RE: 158 Fore Street (Hotel) (Eplan # 2015-169)

Final Review Comment from the Department of Public Works:

SITE PLAN

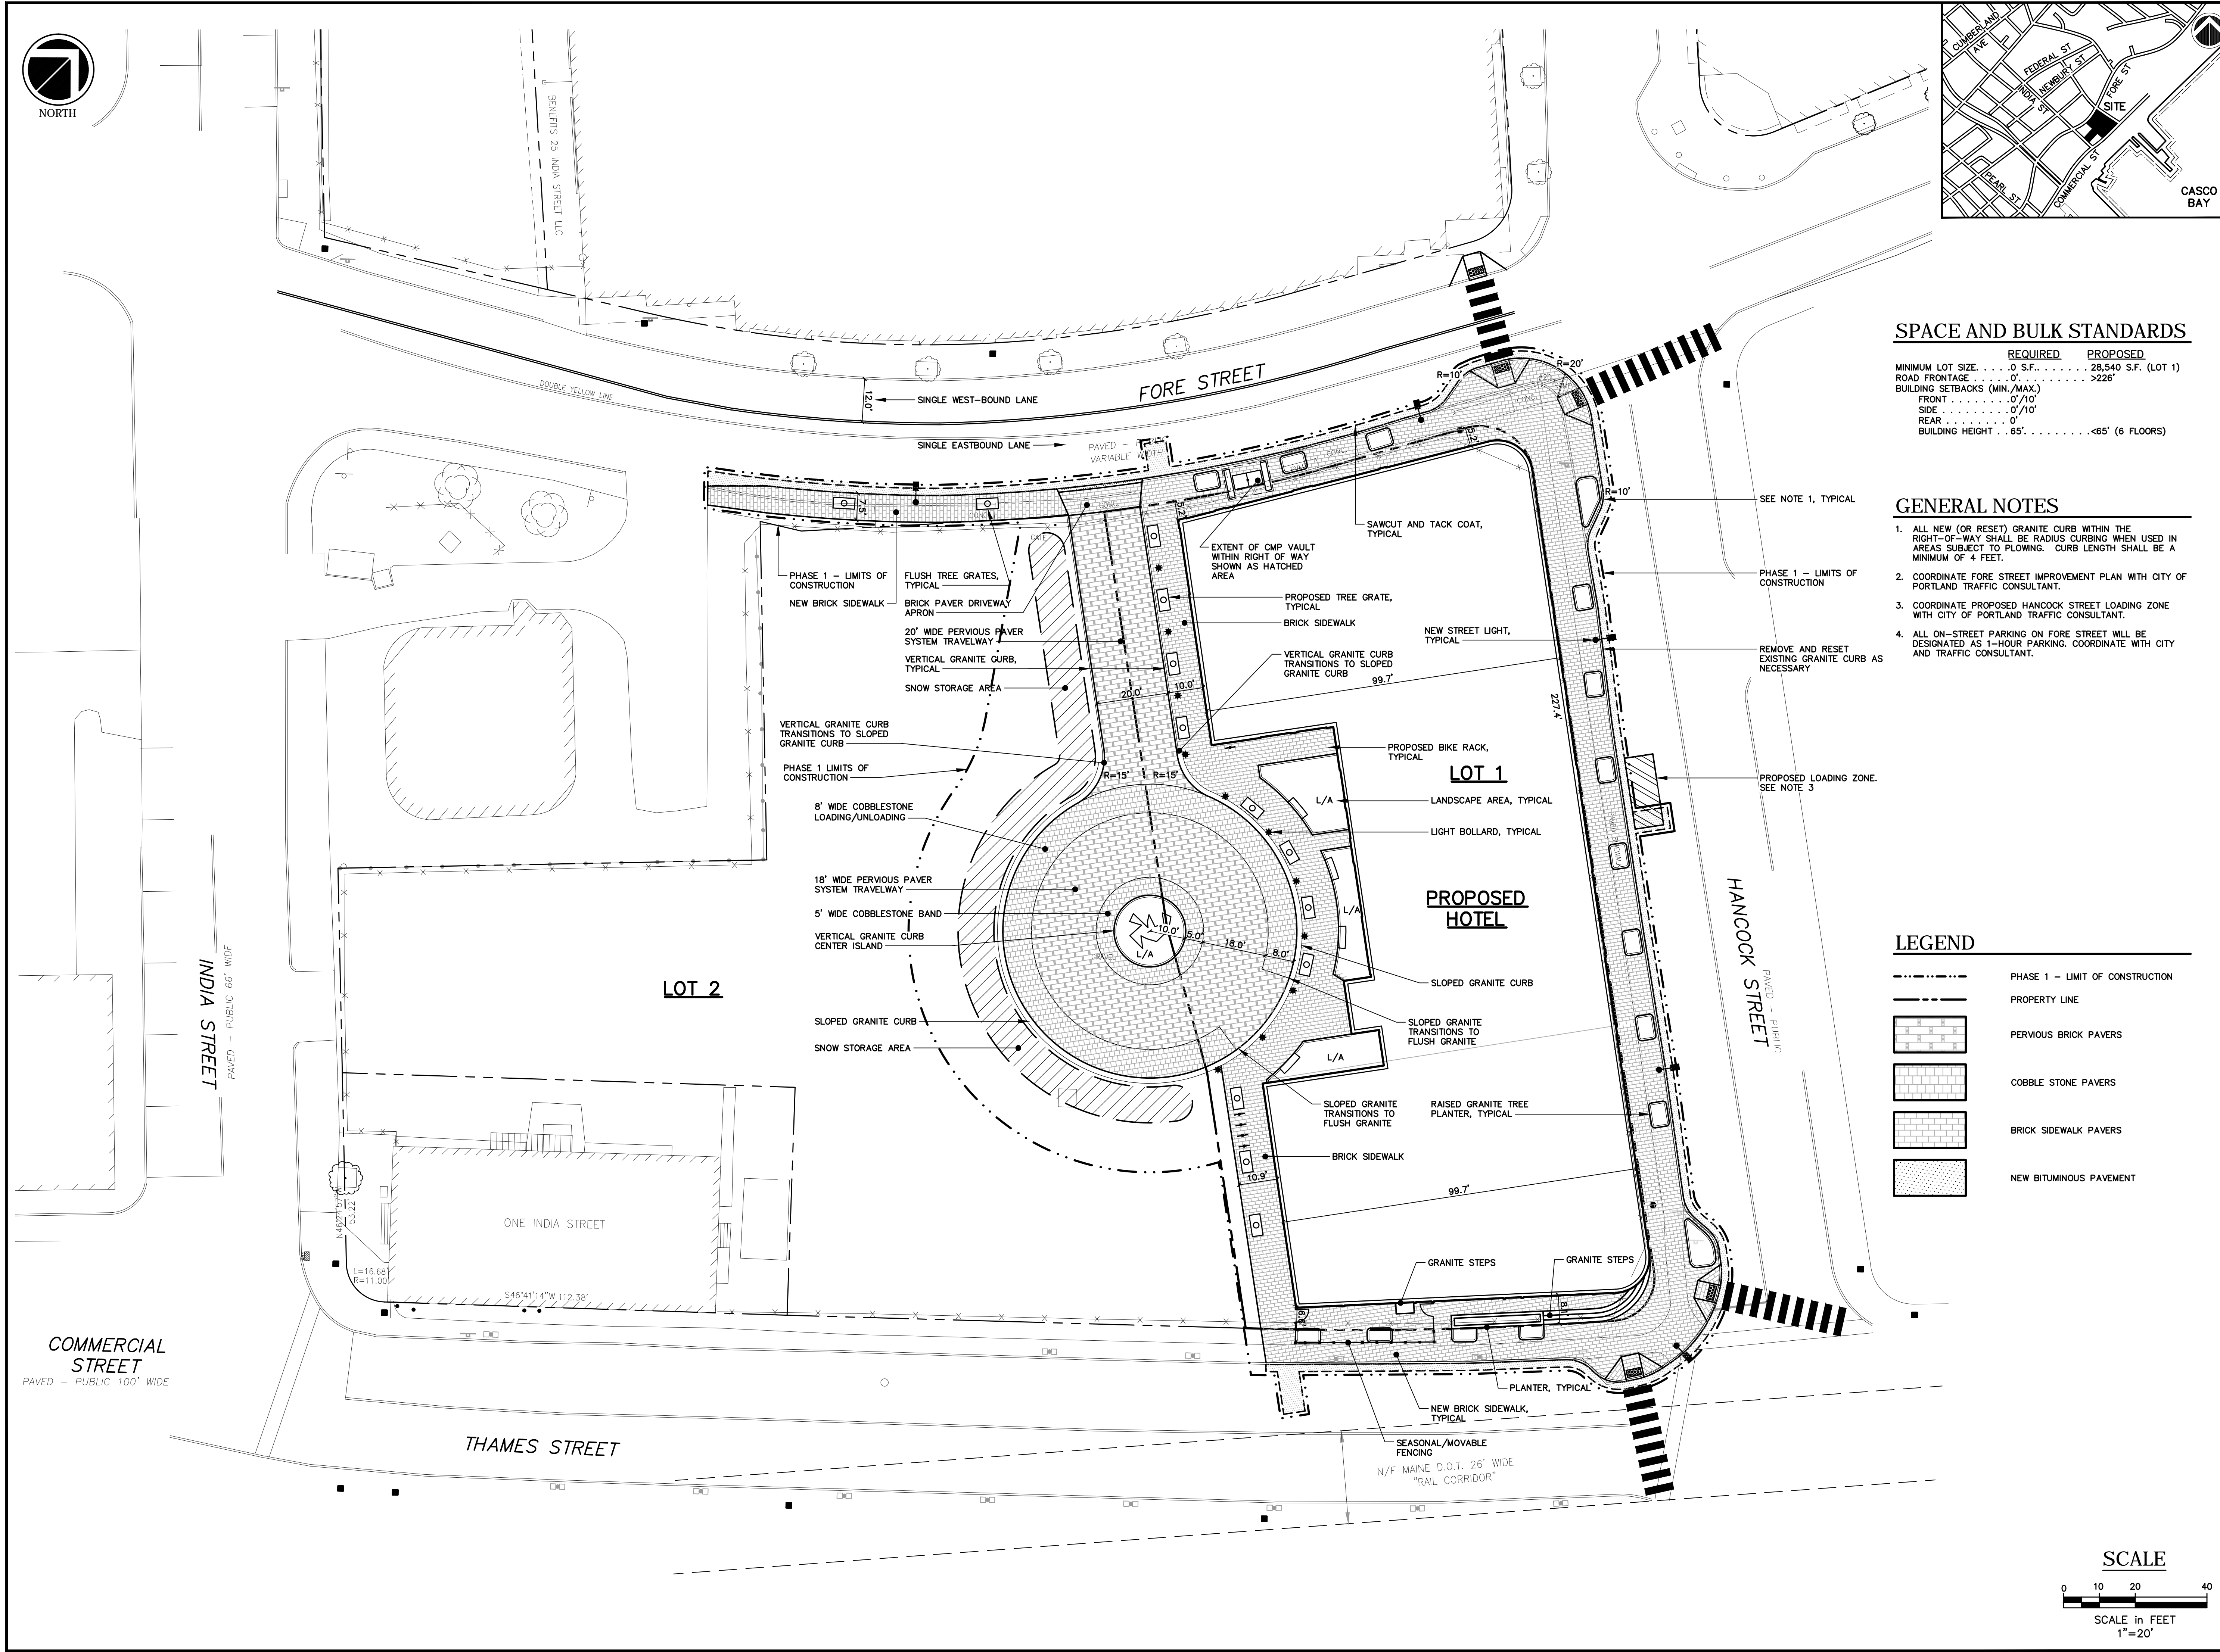
1. Sheet C1.0 – Site Plan, the applicant is showing a brick driveway apron and has asked where the code states an asphalt drive is required. It is my understanding that the City Council in 2000 passed such a material policy and that any change from this policy requires Council authorization.
2. Sheet C1.2, Grading, it is desirable to have the pedestrian crossings of Fore St and Hancock St Extension be perpendicular. This issue will need more discussion.
